Our ref: DOC20/464841

Senders ref: SSD 9874

Subject: Walla Walla Solar Farm (SSD 9874) – Response to supplementary information

We have reviewed the 'Biodiversity further response' and 'Amended Biodiversity Development Assessment Report (BDAR)' (V1.4b, 26 May) against the BCD submissions dated 2 December 2019 regarding the exhibited EIS and our response to the RTS dated 23 April 2020.

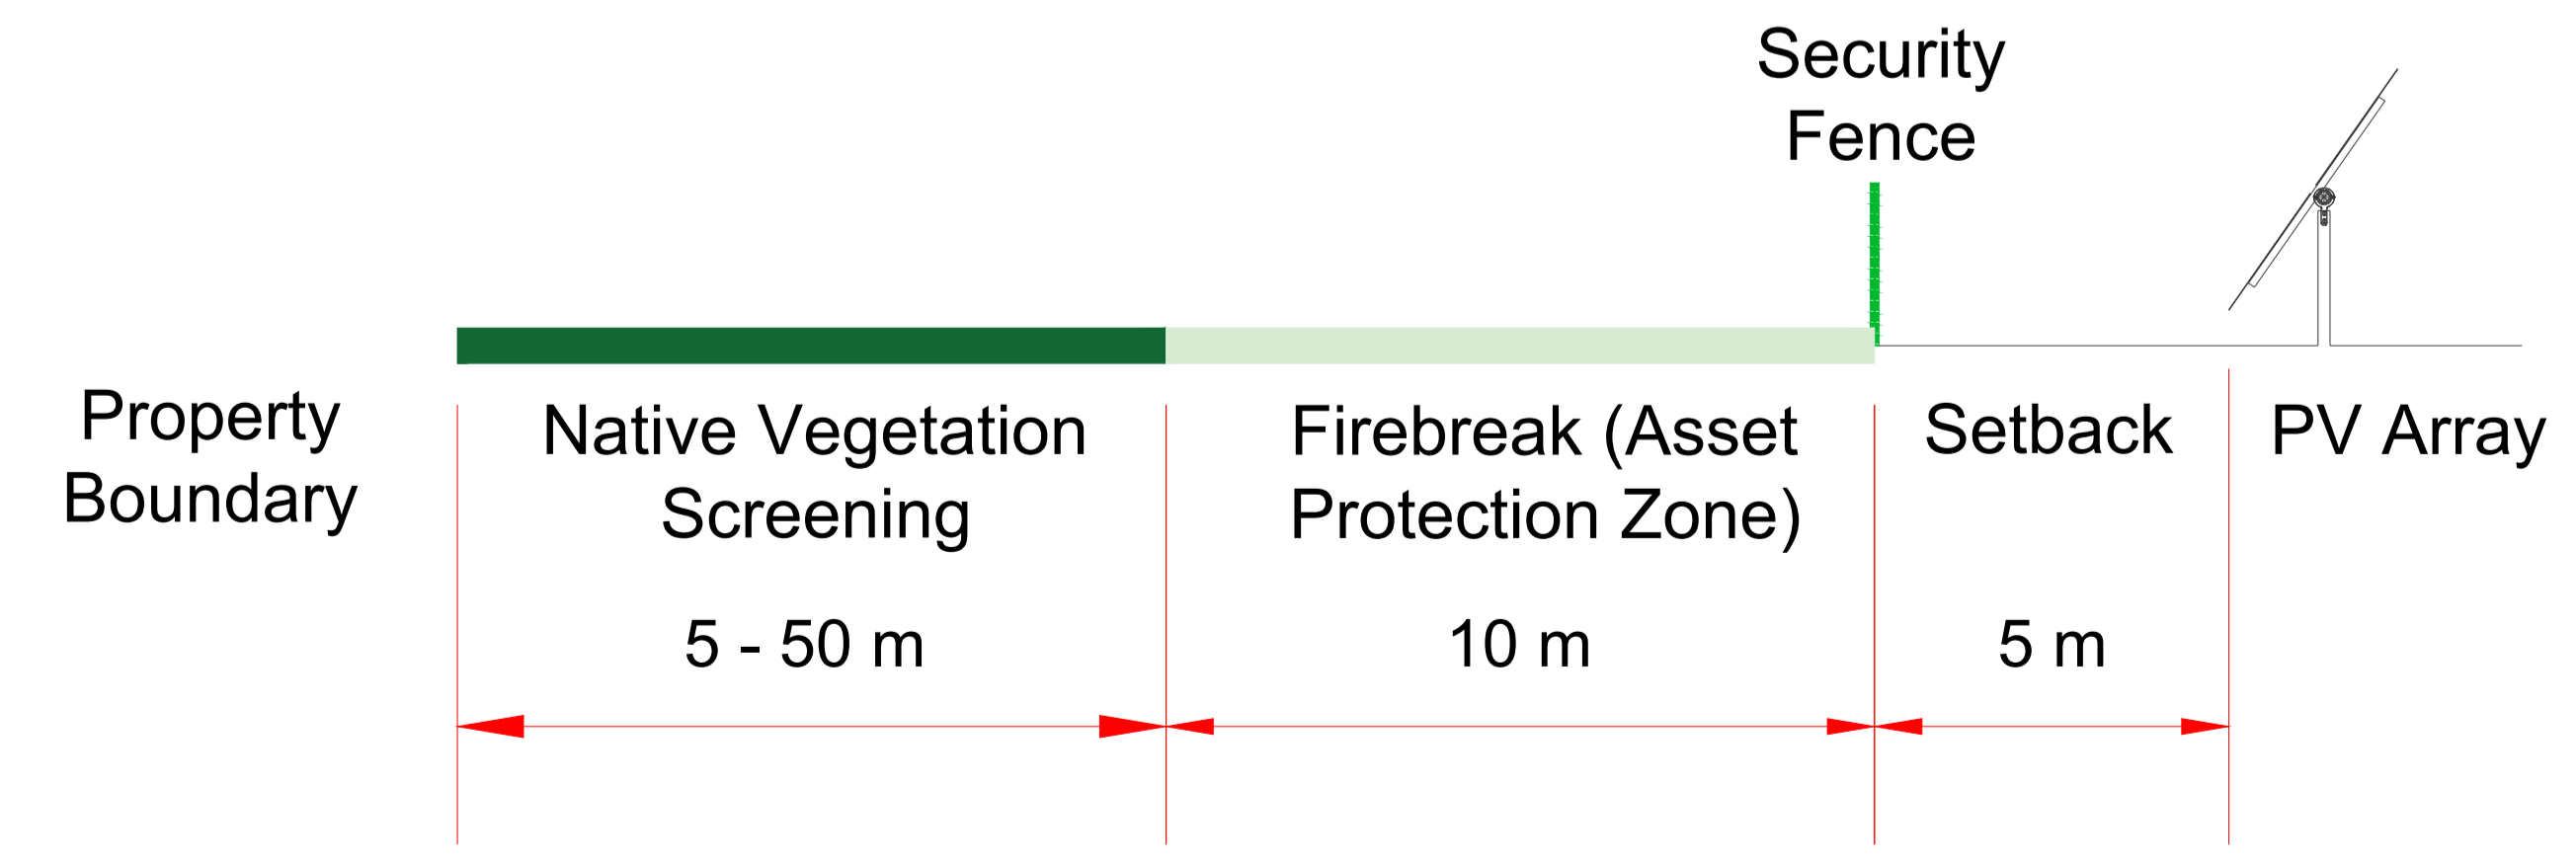
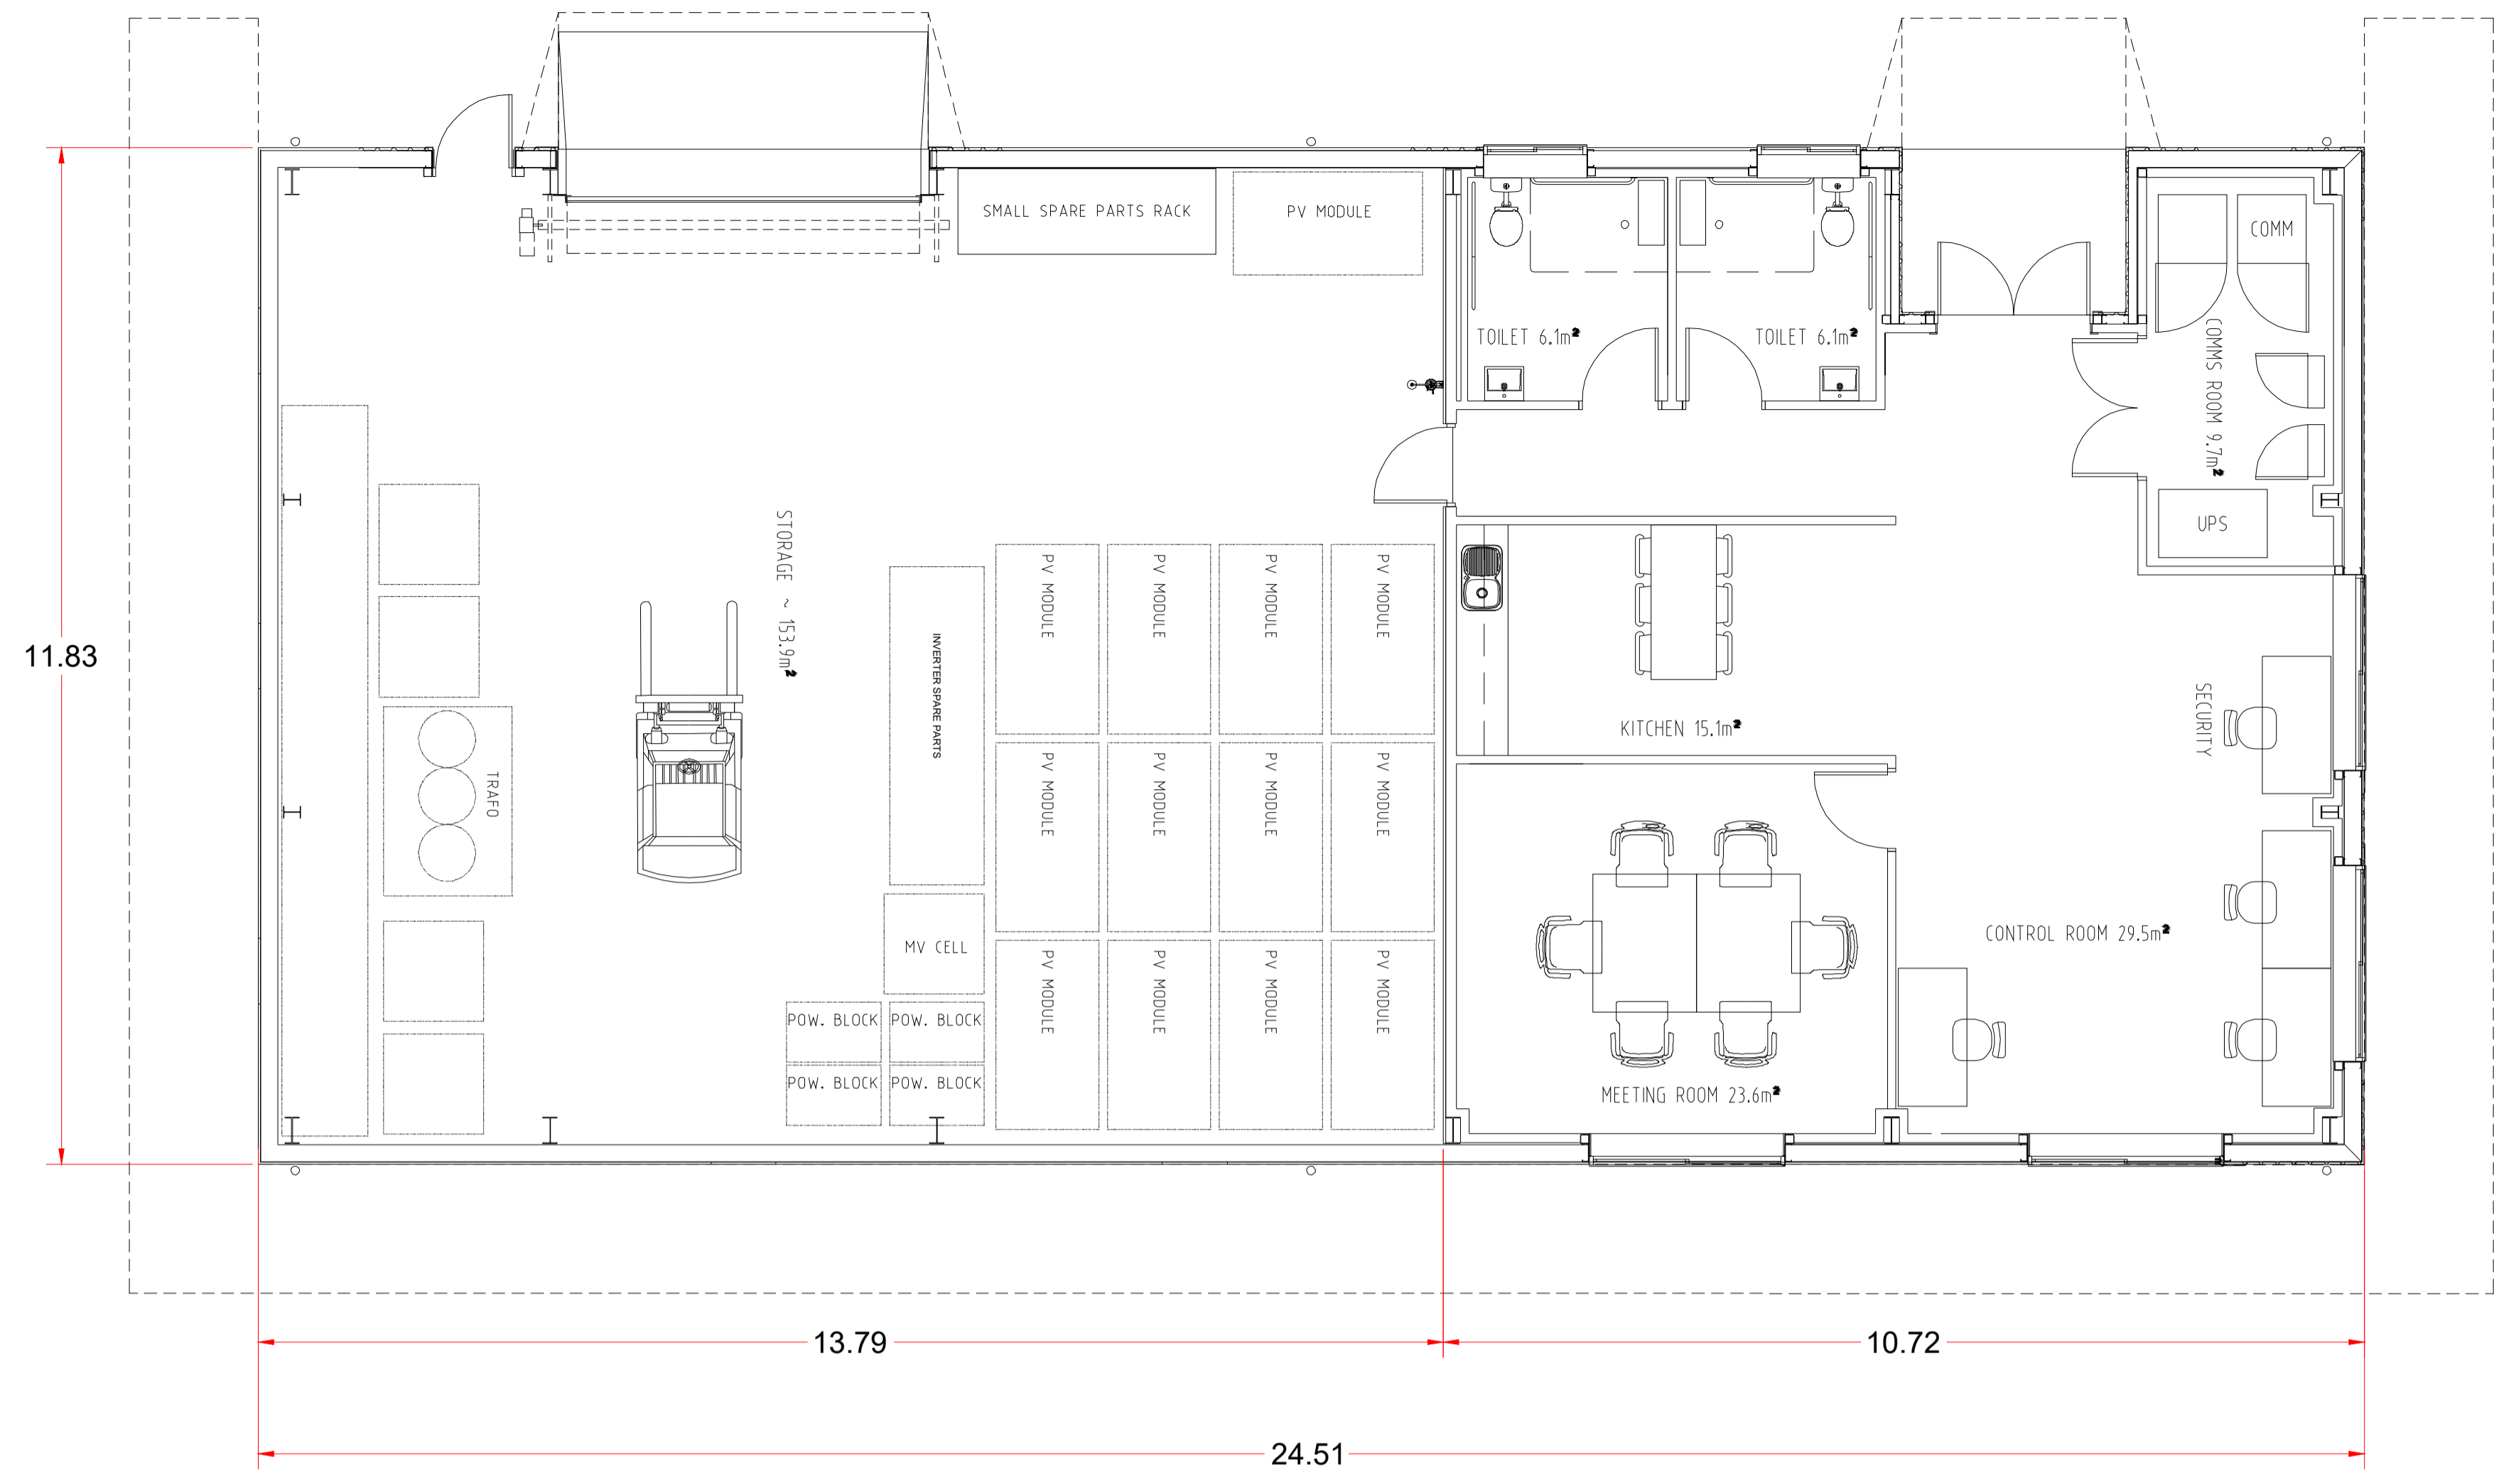
- The vegetation integrity score for Zone 4 has been lowered to zero. Information for the proponent about the BCD approach to assessing impacts of solar panel arrays on native biodiversity is in **Attachment A**.
- Vegetation zone numbering and impact areas are now generally consistent between the submitted digital dataset, revised BDAR and the BAM-C calculator case. Summary Table 10.5 (page 117) still needs to be updated.
- The revised development footprint does not appear to include consideration of security fence construction outside the 10 m asset protection zone.
- The mapped extent of the north-east corner of the proposal site appears to impinge on the road reserve.

1. *Construction and materials laydown areas for security fencing must be within existing cleared areas and inside the approved development footprint.*
2. *Any clearing outside the proposal site must be assessed according to the BAM.*
